ROOF TRUSS LAYOUT
NTS

Client:	Parks Building Supply
Project:	Barton
Model:	00
Lot #:	00
Org #:	00
Date:	
Sales Rep:	Jimmy Eudy
Designer:	Danny Barbee
Order #:	B-73554

Foundation Plan
 Scale: 1/4" = 1'-0"

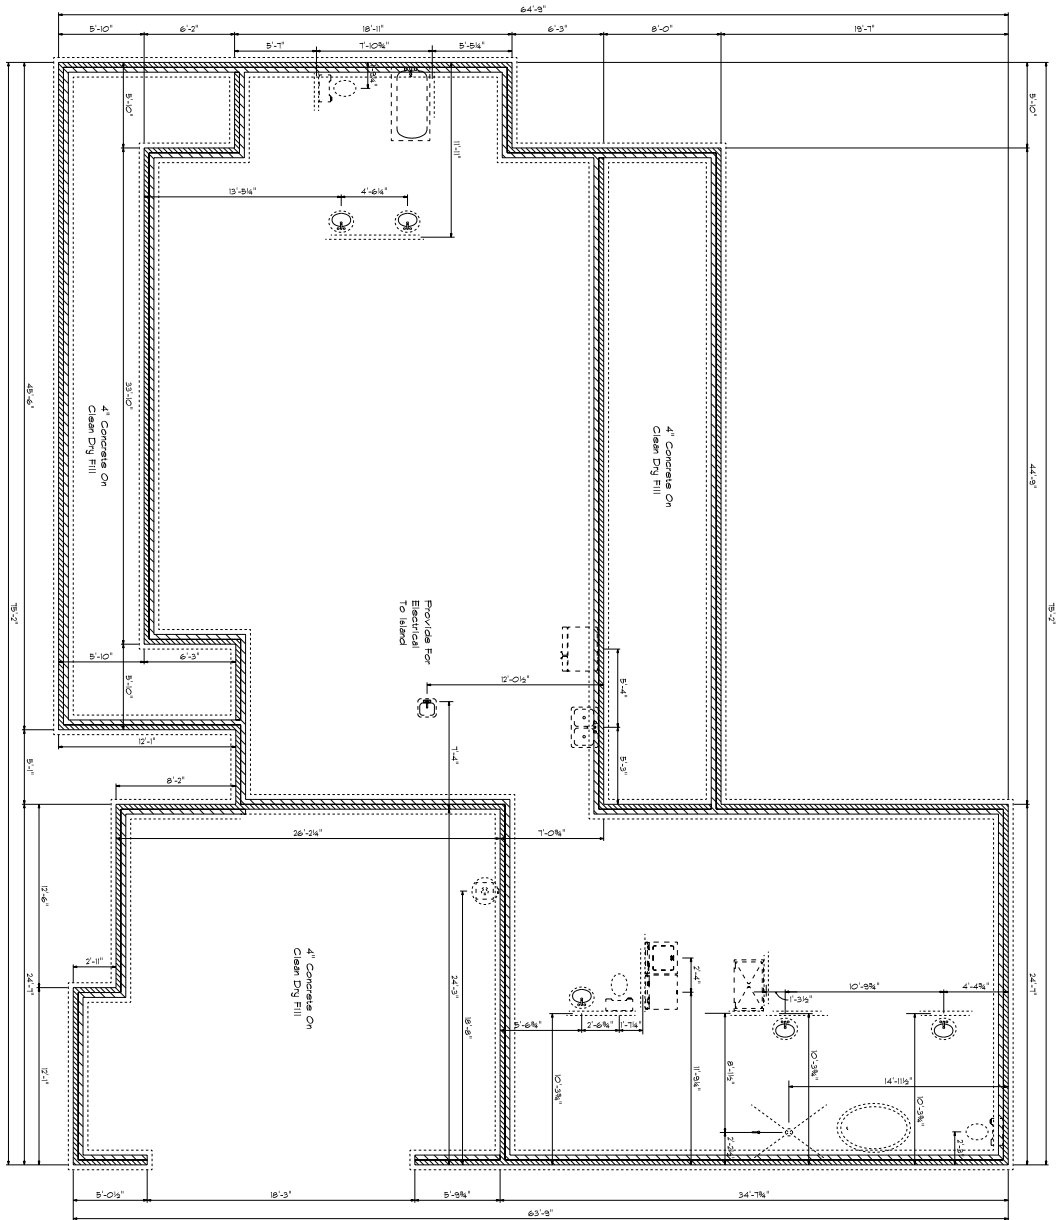
No foundation plan or header/posts shown on plan
